**Application by Mallard Pass Solar Farm Limited
for an Order Granting Development Consent
for the Mallard Pass Solar Project
– project ref. EN010127**

Submission by Sue Holloway – unique ID ref. 20036112

Deadline 2: Written Representation

June 15th 2023

Figure 1 Green Infrastructure Strategy Plan

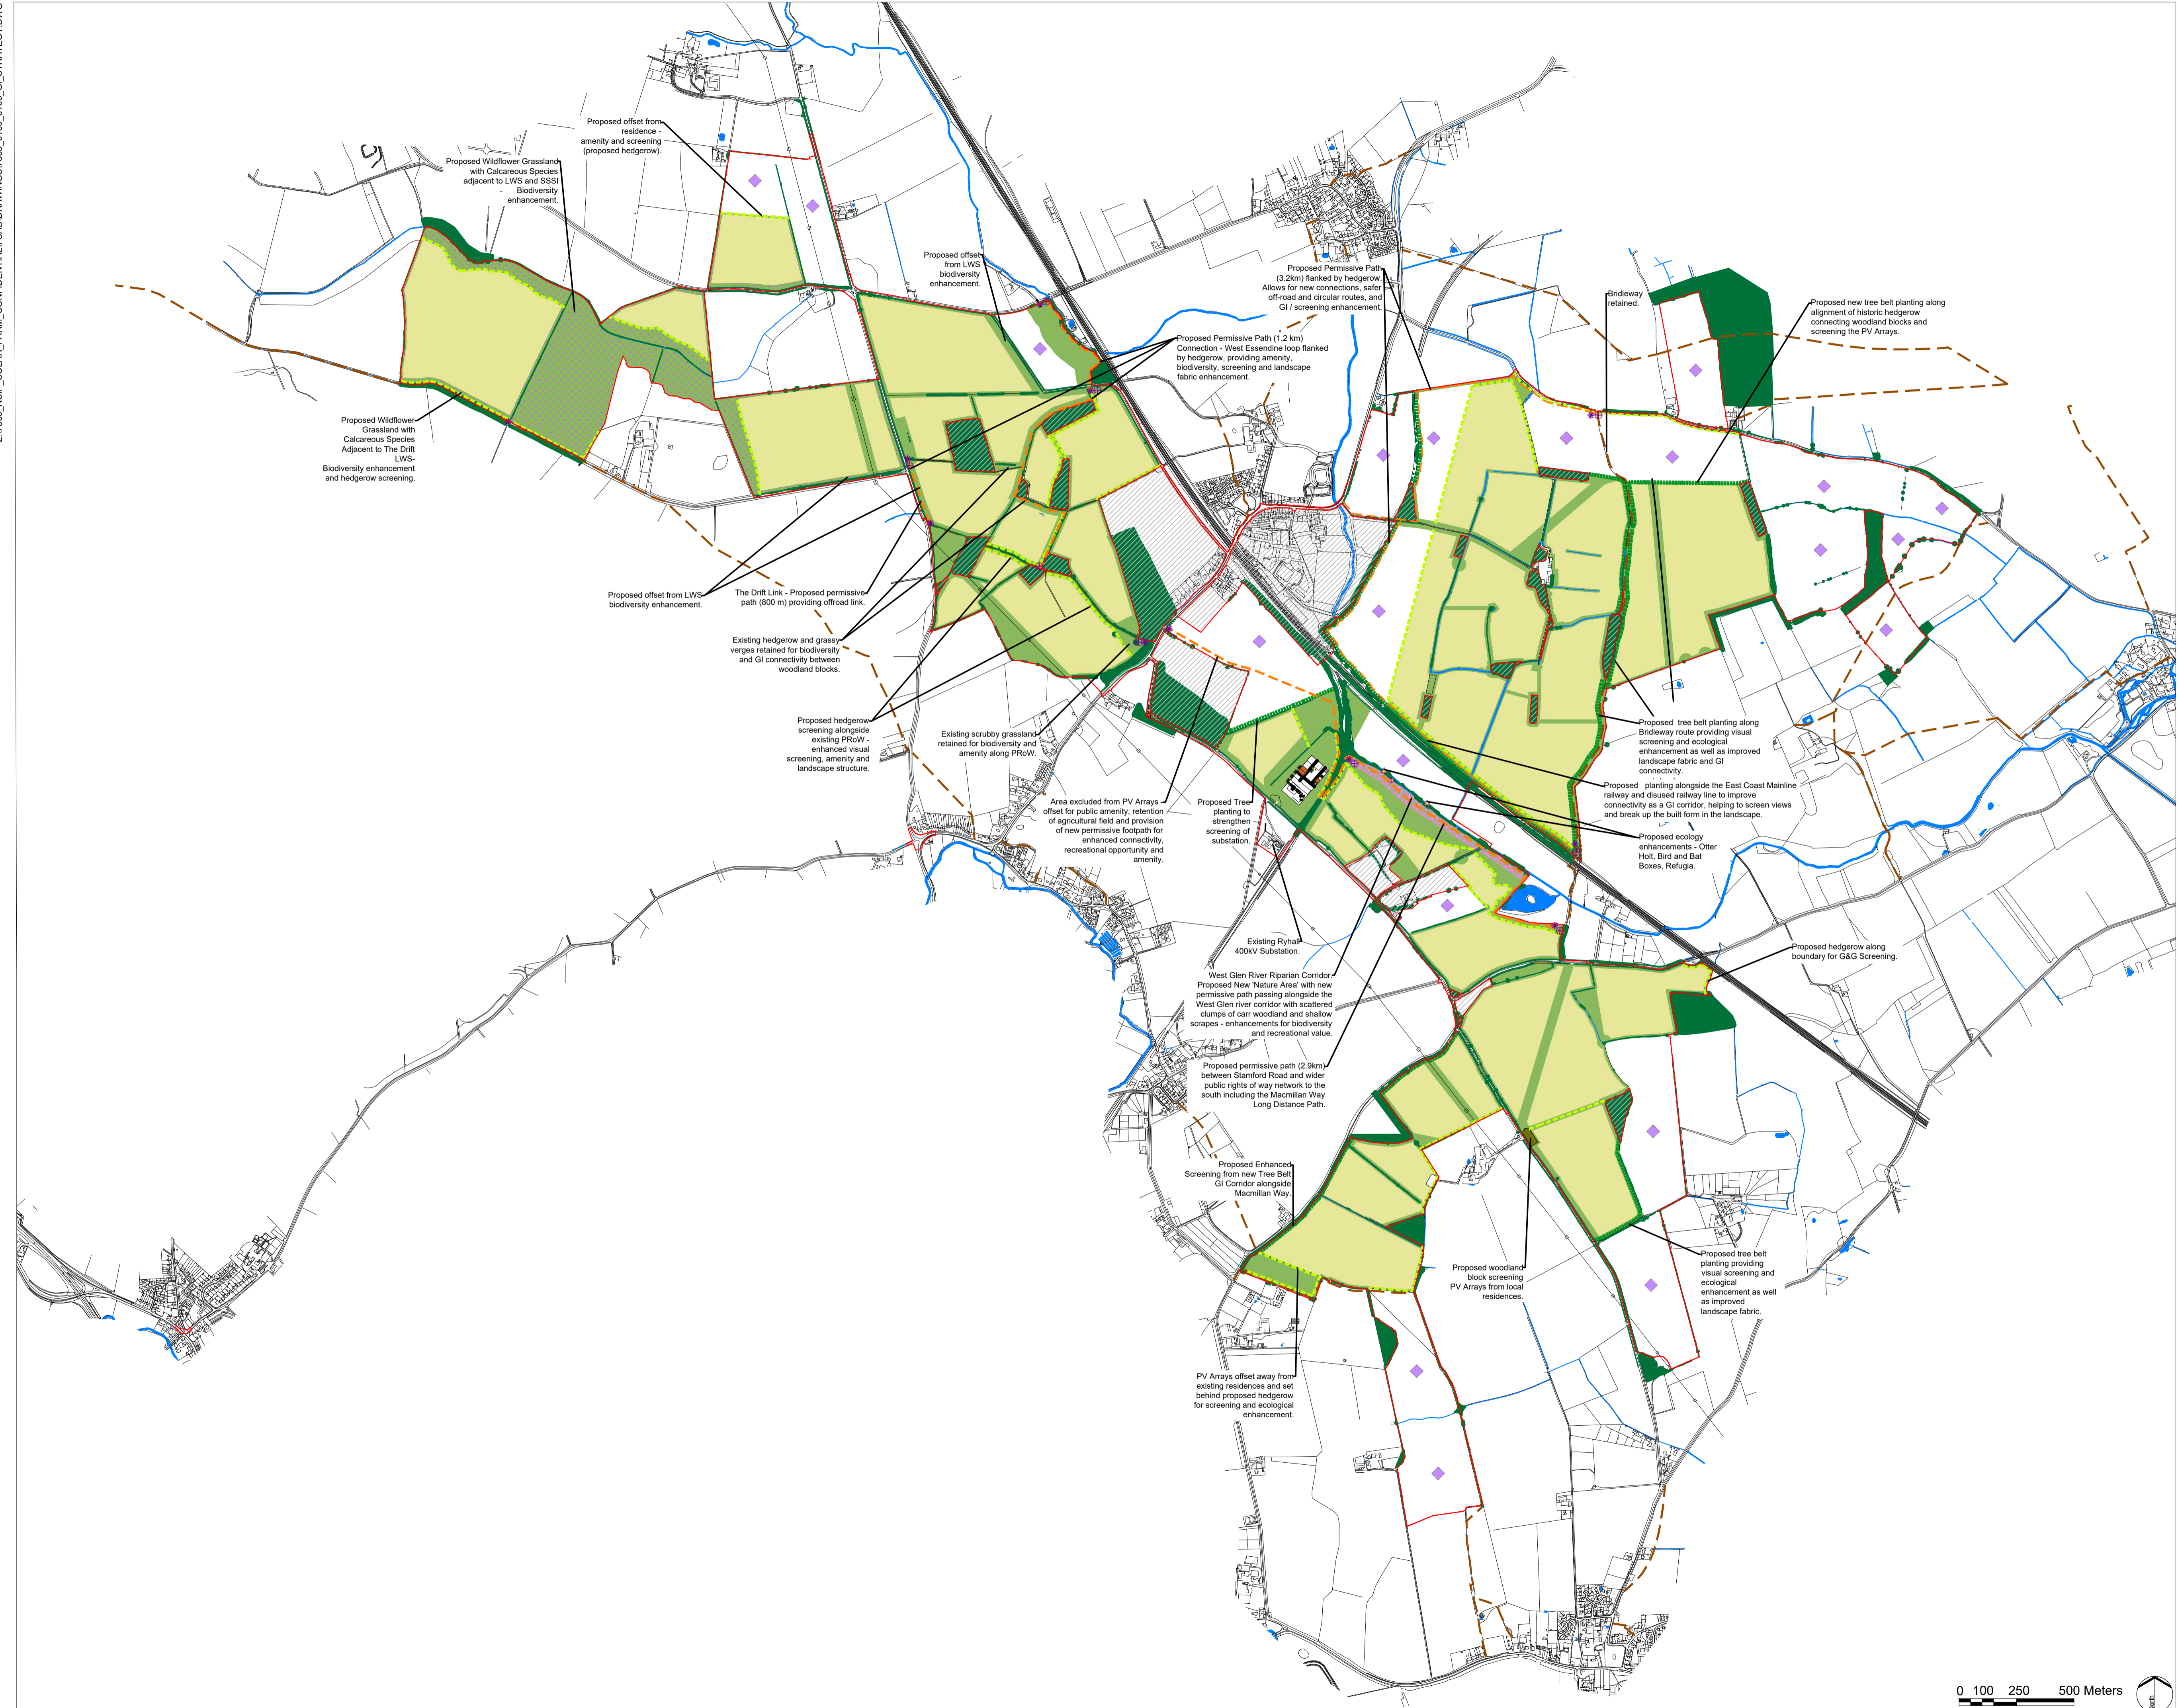
- 5.4.2 However, Figure 1 (figure 6.11 from the Green Infrastructure Strategy Plan (APP-173) as illustrated below) shows new **tree belt planting** not hedgerow as described above.

5.4.3 Planting a tree line is not in keeping with the typical field boundaries and open landscape. The landscape has such far reaching vistas that neither a tree line nor a hedgerow will be effective unless up close to the solar arrays. The lifespan of the development will determine how effective and for how long the 250-300m set-back mitigation will have a screening impact for, especially with respect to tree planting. The lifespan could be as low as 25 years if the technology is superseded, conversely it could be up to 40 years and beyond. Growing a proper thicket hedge would be more appropriate, and if done properly would offer more screening value in the winter months compared to a tree line. It would also replace what used to be a historic hedgerow between those tree belts.

5.5 If this Application were to be approved I would ask that the Applicant sensitively consider the point above and confirm their proposed mitigation. This was raised in my Stage 2 consultation but never received any response from the Applicant.
